GOVERNMENT ARCHITECT NEW SOUTH WALES

28th October 2021

PROJECT: Mulgoa Rise Public School
RE: SDRP– 20th October 2021 – Second Review

Drawing Title
SITE ACCESS AND SECURITY PLAN

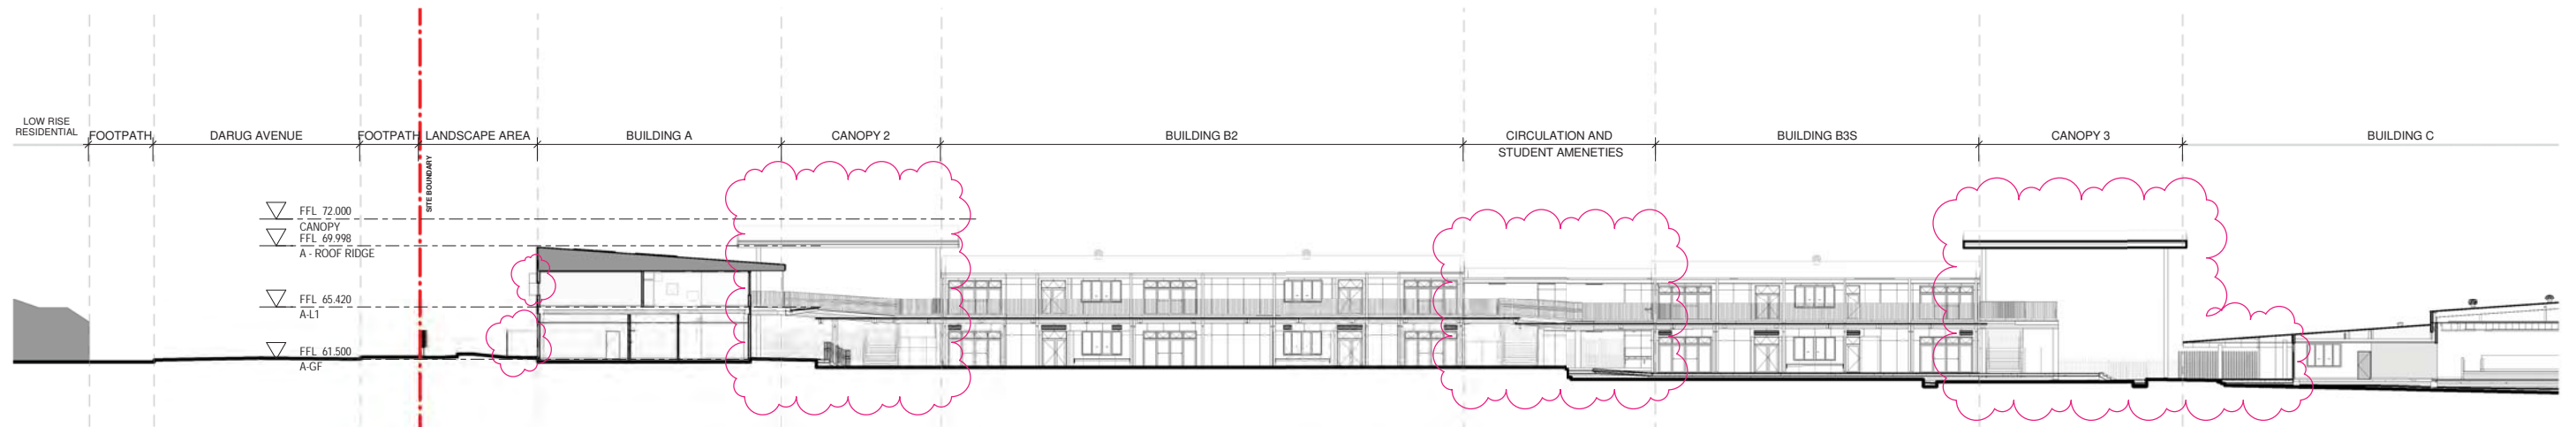
10. The fencing diagram submitted as part of the EIS indicates a multiplicity of primary and secondary security lines and is not supported.
 - a) Simplify and clarify the extent, height and necessity of fencing proposed. Review the role and size of the entry spaces and spaces between the street and buildings so that double fencing is not required. There should be a single line of security around the site. Buildings and landscape can be part of this line.

- b) The masonry fence on the corner of the site and fencing along Deerubin Drive are very high and create an imposing character to the street. Consider lowering the height of these where possible and/or softening their impact with landscape design.

1 DEERUBBIN DRIVE ELEVATION - PART 1
1 : 200

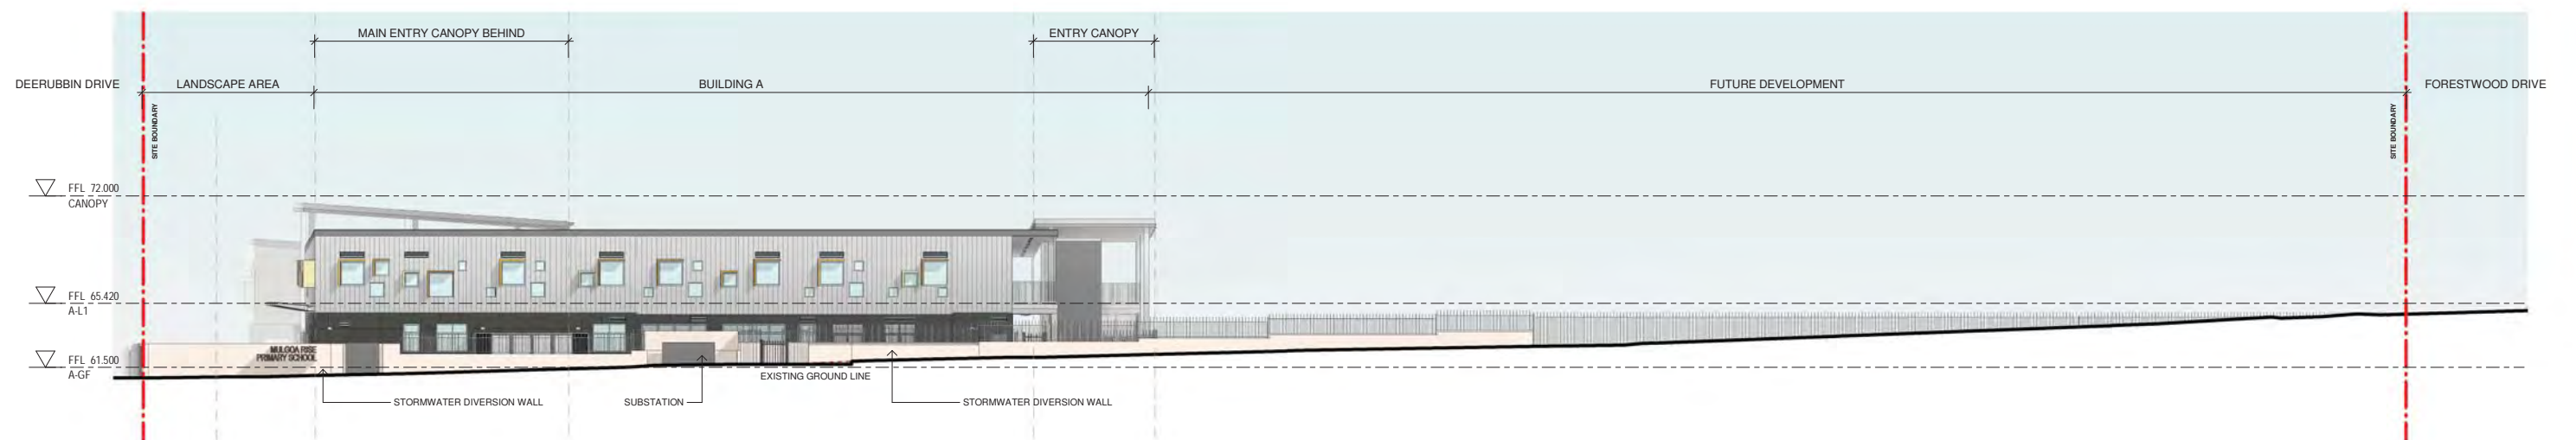
- a) The alignment of the building line lacks clarity and coherence along the length of Deerubin Drive. Review the plan and façade design and alignment of this edge to ensure a legible street presence of the school.

- b) Review the scale, hierarchy, and design detail of the entry points to announce places of public drop off and community access.
